Re: Status of Improvement Permit Application #06-5-14688R – Lt 53 Forest Oaks

An Environmental Health Specialist from the Harnett County Health Department attempted to evaluate your property for the purpose of issuing an Improvement Permit. This individual was unable to evaluate your property for one or more of the following reasons.

Re: Status of Improvement Permit Application #06-5-14688 – Lt 53 Forest Oaks

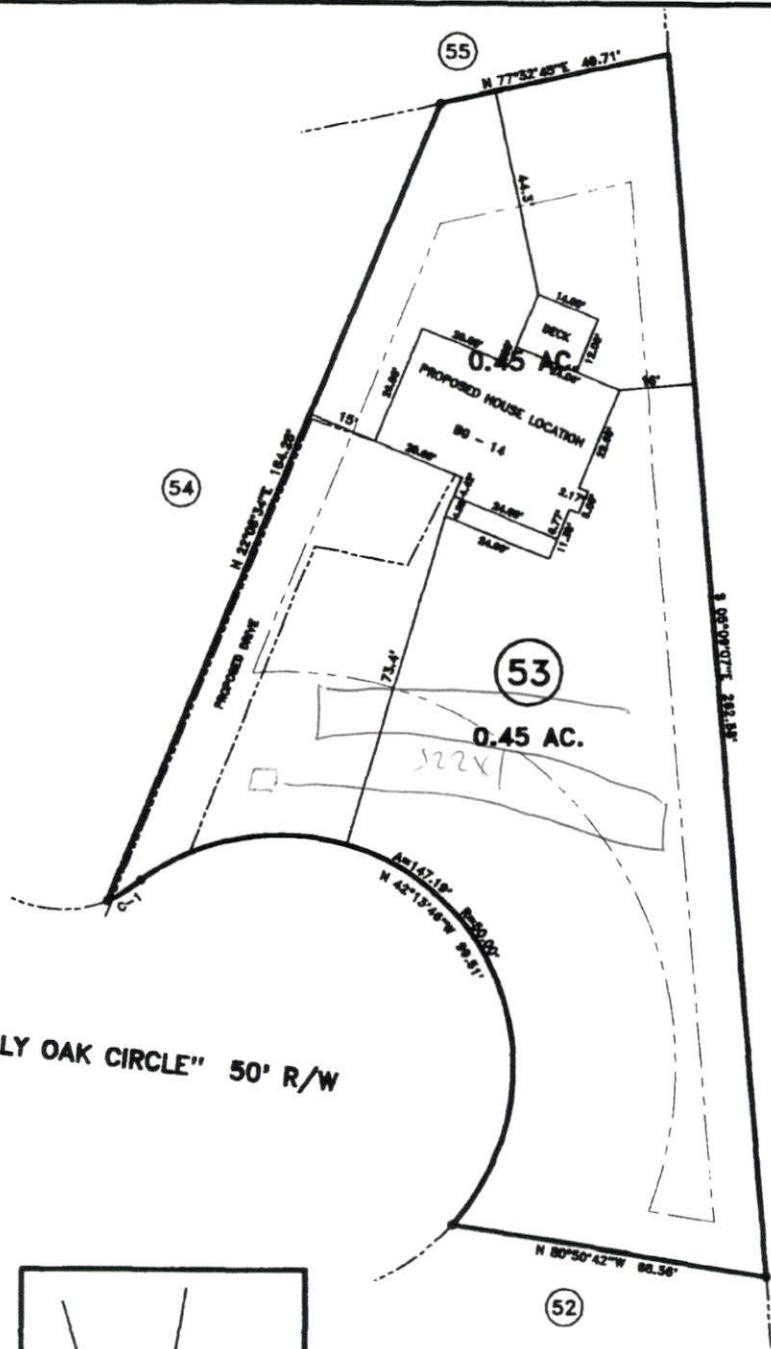
1. Property lines/corners not marked or labeled – *Please stake correct house corners as per new plot plan submitted and also stake corner irons.*

SURVEY FOR: PROPOSED PLOT PLAN - LOT - 53 FOREST OAKS S/D, PHASES ONE & TWO		BENNETT SURVEYS, INC. 1662 CLARK RD., LILLINGTON, N.C. 27546 (910) 893-5252	
TOWNSHIP ANDERSON CREEK	COUNTY HARNETT	20 0 40	SURVEYED BY: FIELD BOOK
STATE: NORTH CAROLINA	DATE: APRIL 17, 2006		DRAWN BY: DUB

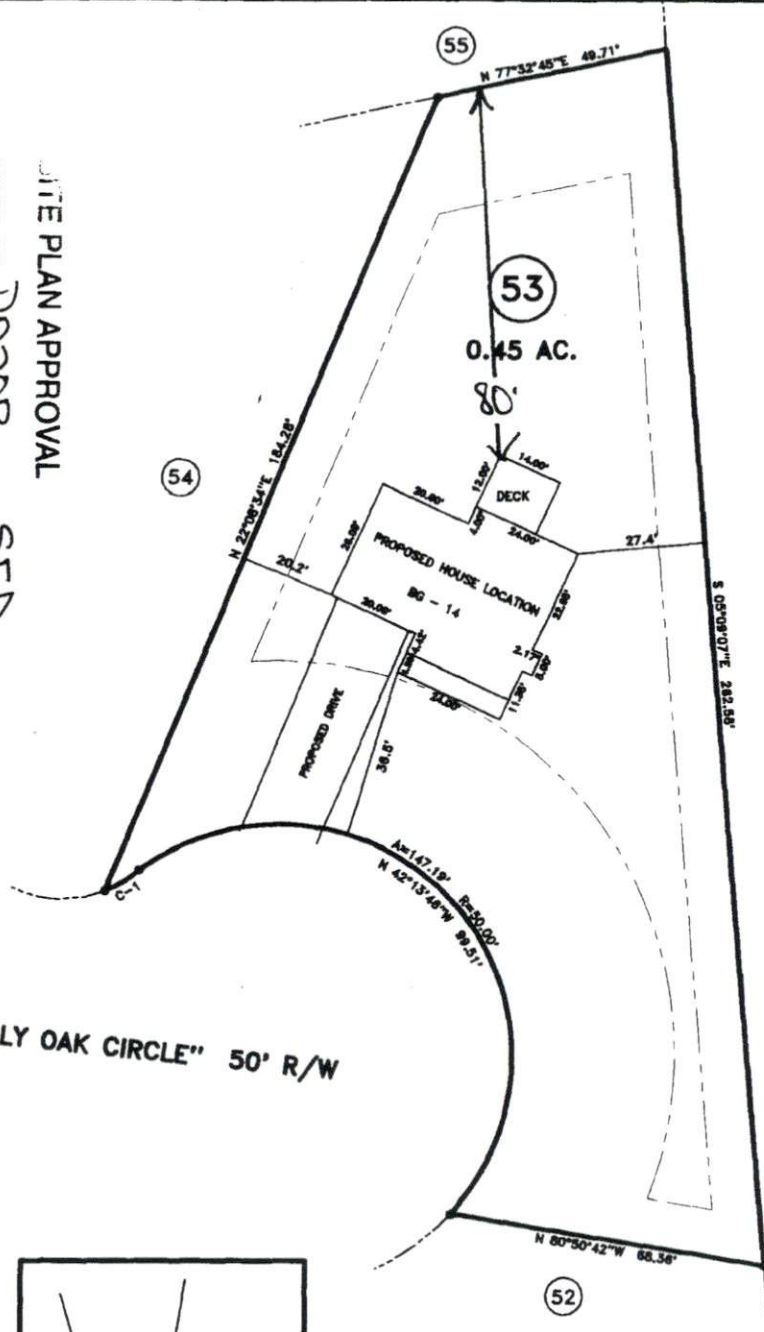
- 1. Property lines/corners not marked or labeled
- 2. House corners not marked or labeled
- 3. Directions not clear to property
- 4. Property needs brush or vegetation removed
- 5. Backhoe pits required
- 6. Other – **Move house site as per attached sheet.**

STAKE ^{NEW} house site = so I can do septic layout.
